Our Ref: EG/33/11/
Your Ref:

Please ask for:
Mrs S Honney-Bayes
01903 737500 Ext 37445
9th June 2011

Proposed redevelopment of land to provide 13 no. new dwellings to include 4 no. 2 bed houses, 6 no. 3 bed houses, 1 no. 4 bed house & 2 no. 5 bed houses. Together with associated access, car parking, landscaping & retention of existing property Greenoaks Barnham Road Barnham

PLOTS 5, 6, 9 & 10 (plots 9 & 10 mirrored)

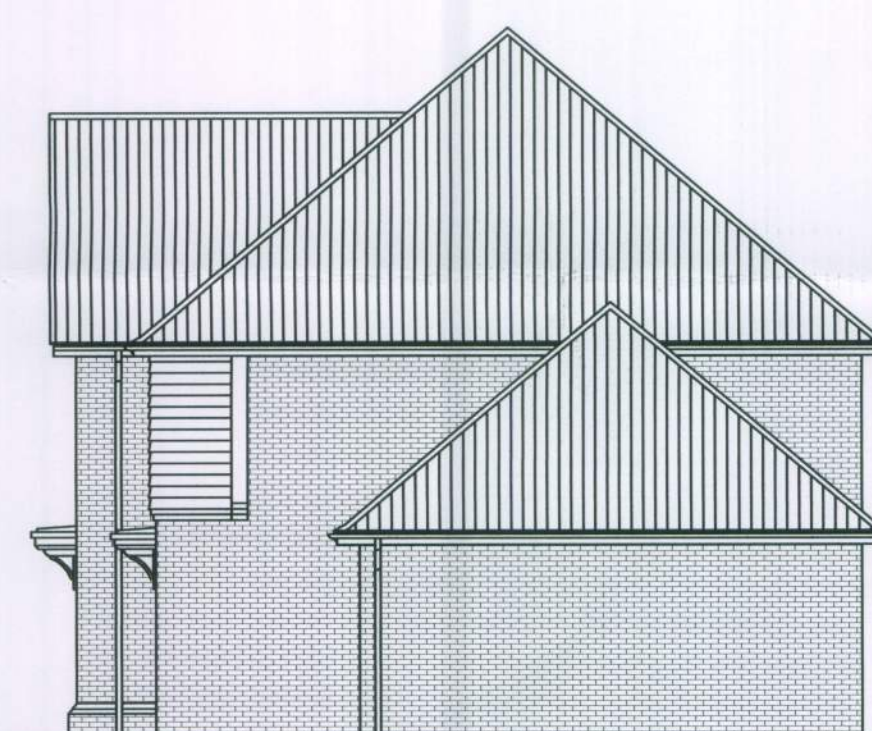
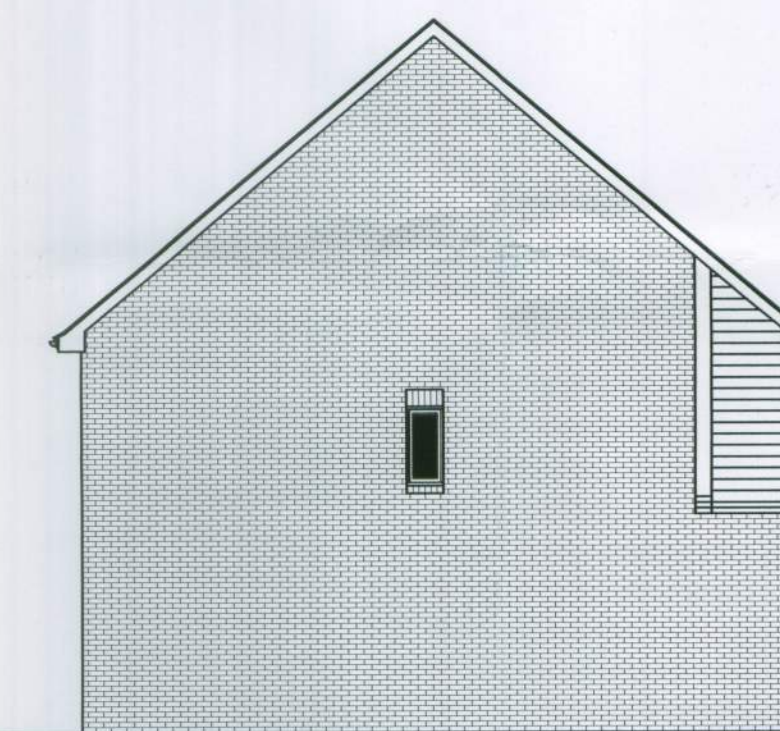
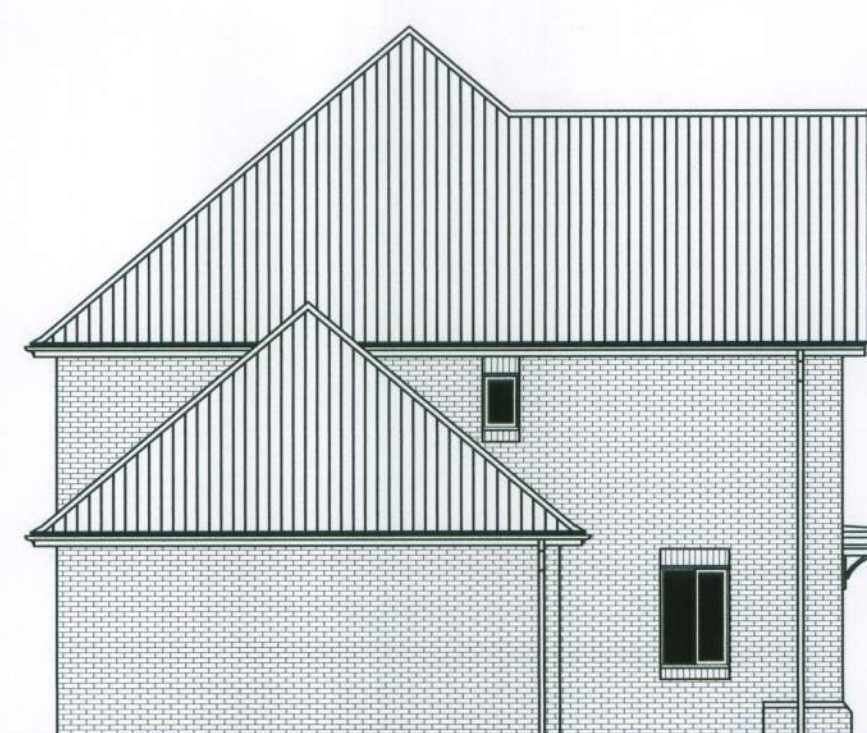
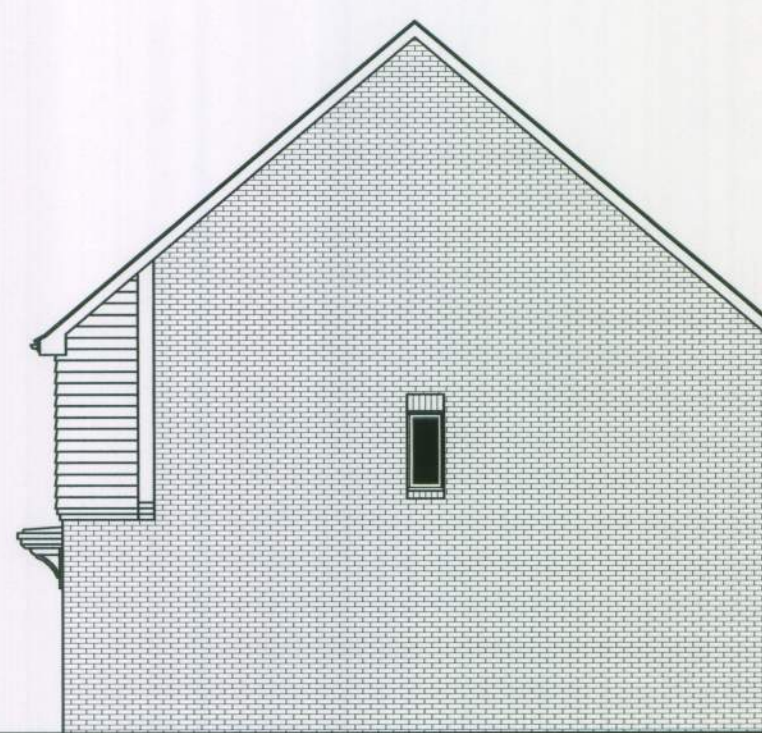
Please provide 1 electronic or 3 paper copies of a revised proposed side elevation (plan no. 05 - plots 6 & 9) to show the first floor bathroom window as detailed on the floor plan, in accordance with the guidance notes available on our website detailed below (click on National List).
